Re: Wellington North Solar Farm SSD-8895 – Request for Information (RFI) 17-382

NGH have prepared responses to the RFI for Wellington North Solar Farm SSD-8895 on behalf of Wellington North Solar Farm Pty Ltd (“the proponent”), as discussed in consultation with AGL and DPIE. Points have been grouped together where the requests were of a similar theme. Each information request from DPIE is provided in **bold italicised** text, above the proponent’s response.

Figure 2-3 Transport Route.

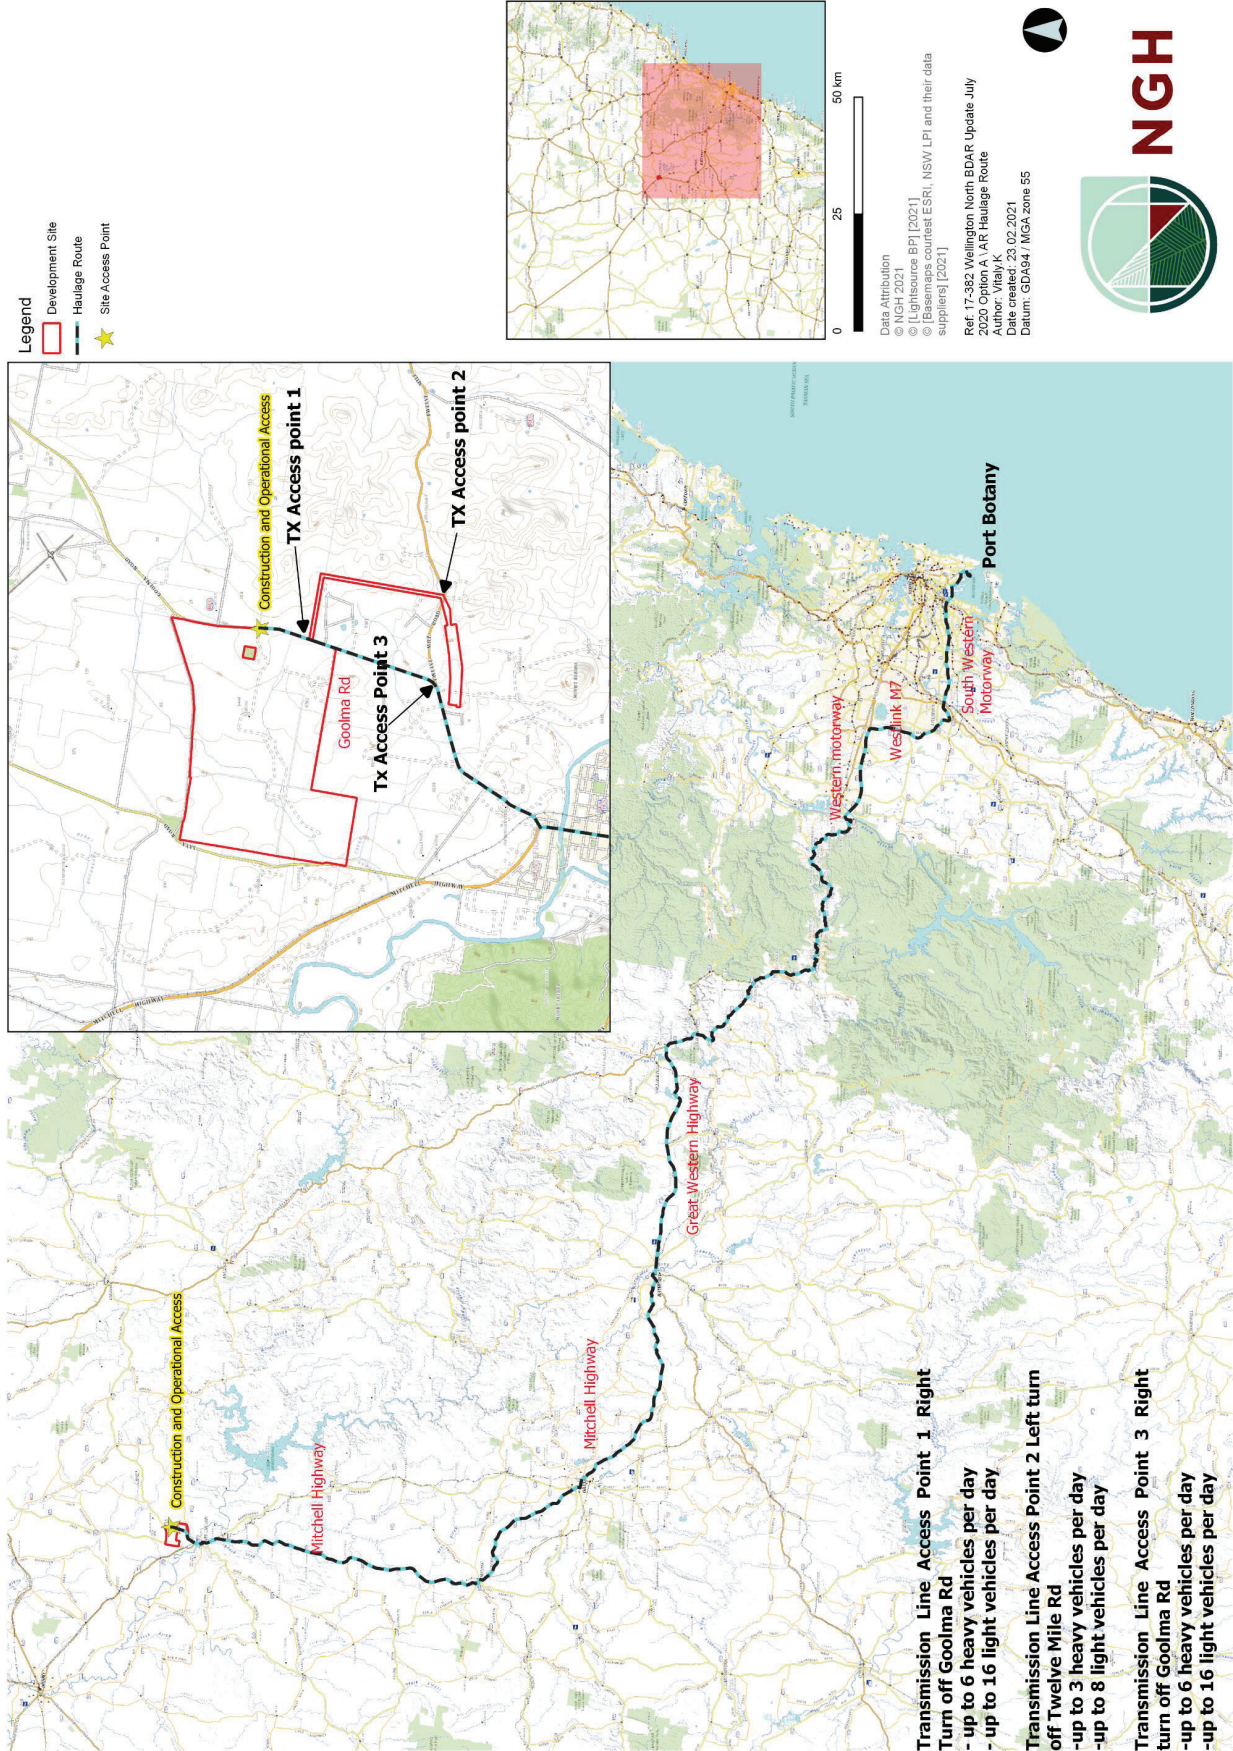
Provide a figure demonstrating the proposed transportation route, and identifying the zone of potential cumulative traffic impacts with Maryvale Solar Farm.

The proposed transportation (haulage) route is provided in Figure 2 below. The area of highest potential cumulative traffic impacts for heavy traffic has been identified as a short section of Cobbora Road (highlighted as the potential common haulage route on Figure 2 below) located between Maryvale Road and Campbells Lane. It is noted that only the transmission line heavy vehicles may have a potential common haulage route between Campbells Lane and Bella Vista Lane/Mitchell Highway. The cumulative impacts would also depend on construction timing for the proposed and all surrounding developments and direction of travel for heavy vehicles for the transmission line which may take an alternate route of Campbells Lane to Goolma Road therefore avoiding potential conflicts between Campbells Lane and Bella Vista Lane/Mitchell Highway.

Figure 3-2 PCTs and TECs at the development site (north).

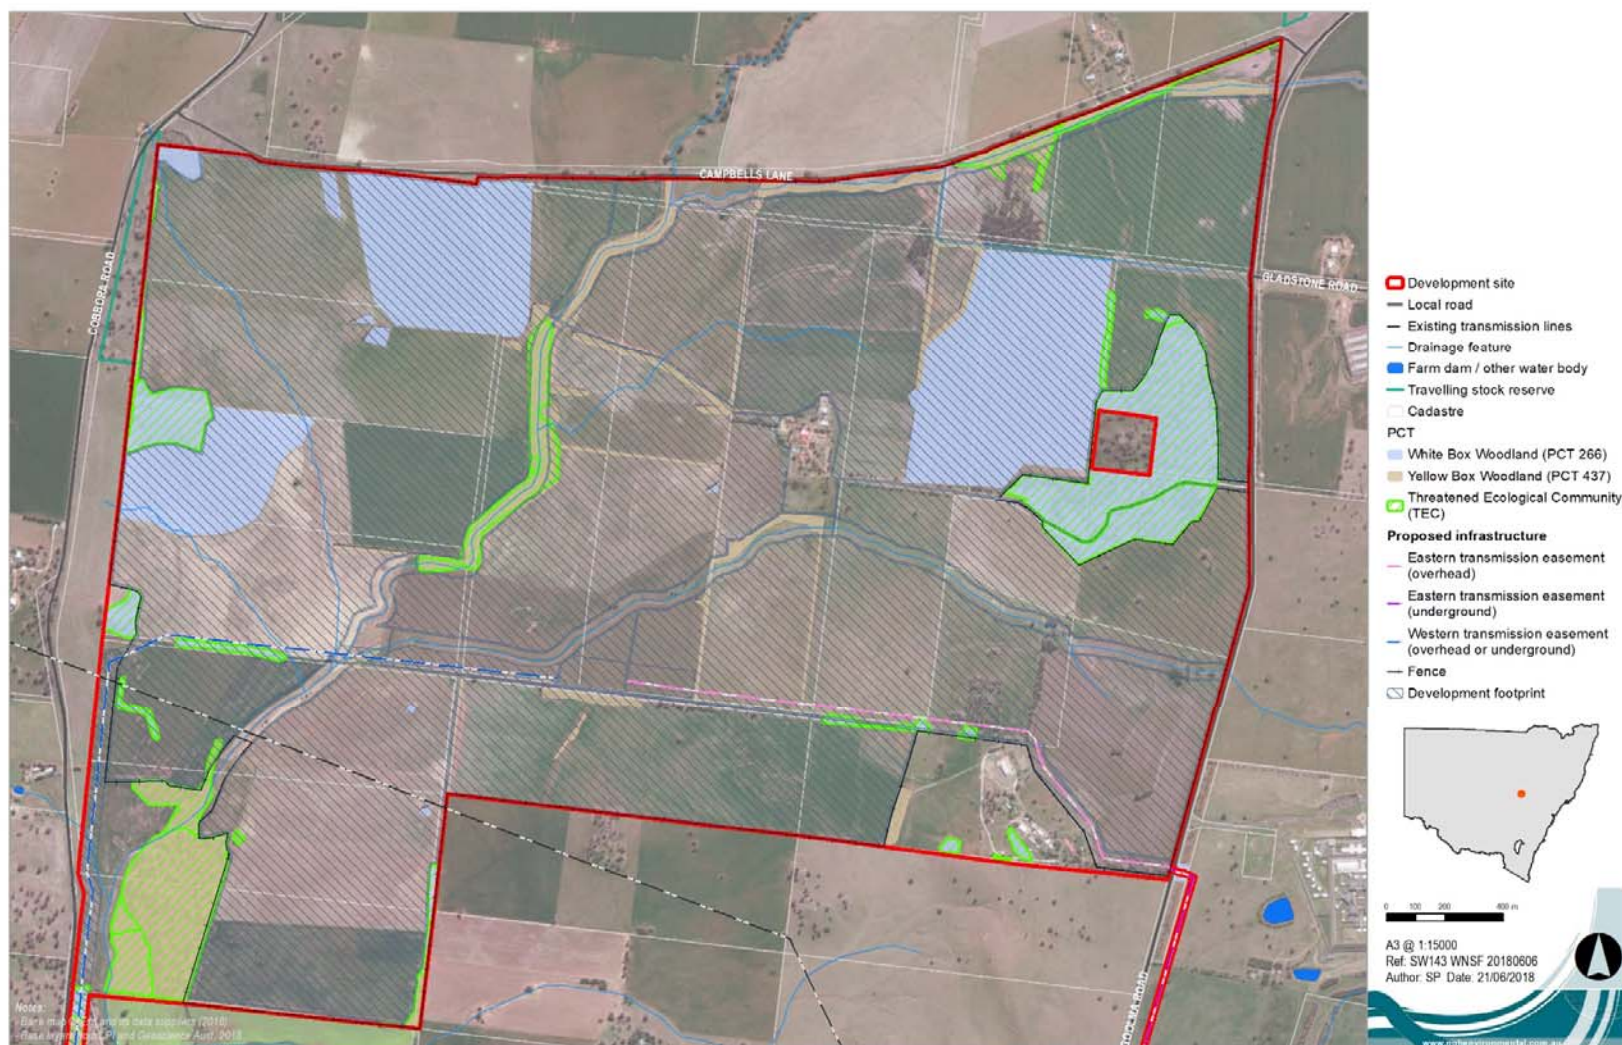
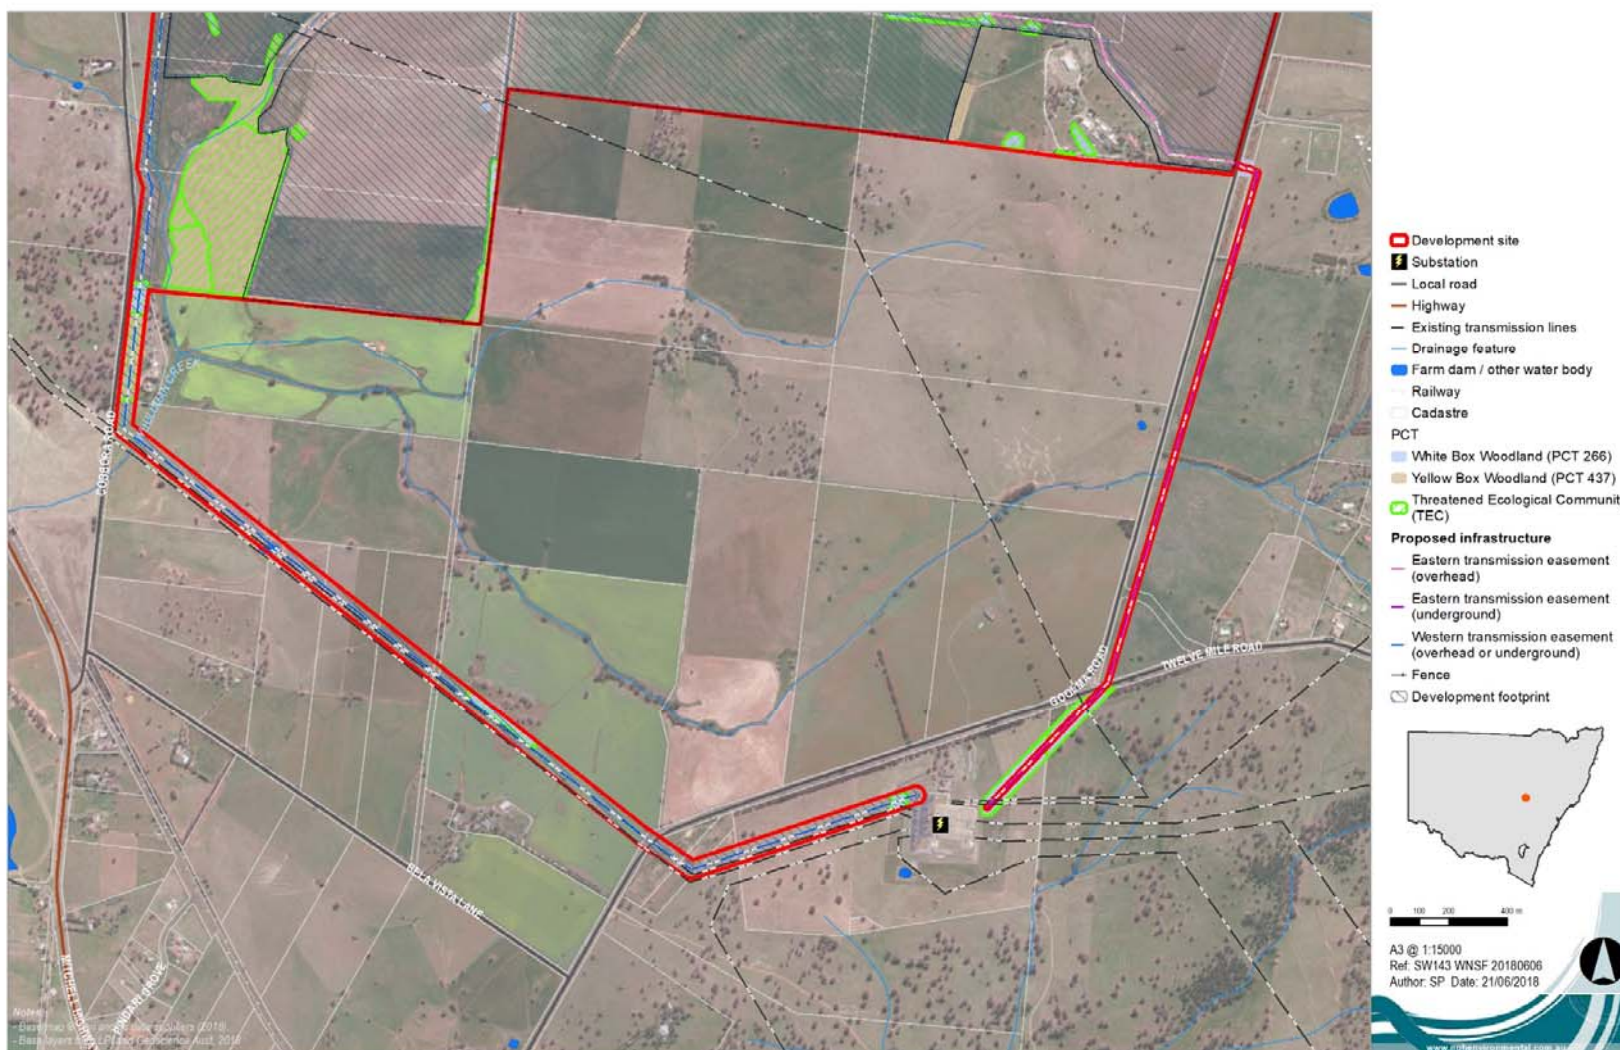
Provide a figure identifying the areas of proposed vegetation clearance.

It is understood that DPIE is satisfied that the mapping provided in BDAR v2.3 (NGH, 2019), specifically figure 3-2 and 3-3 showing the proposed areas of clearing, and that no additional maps are required.
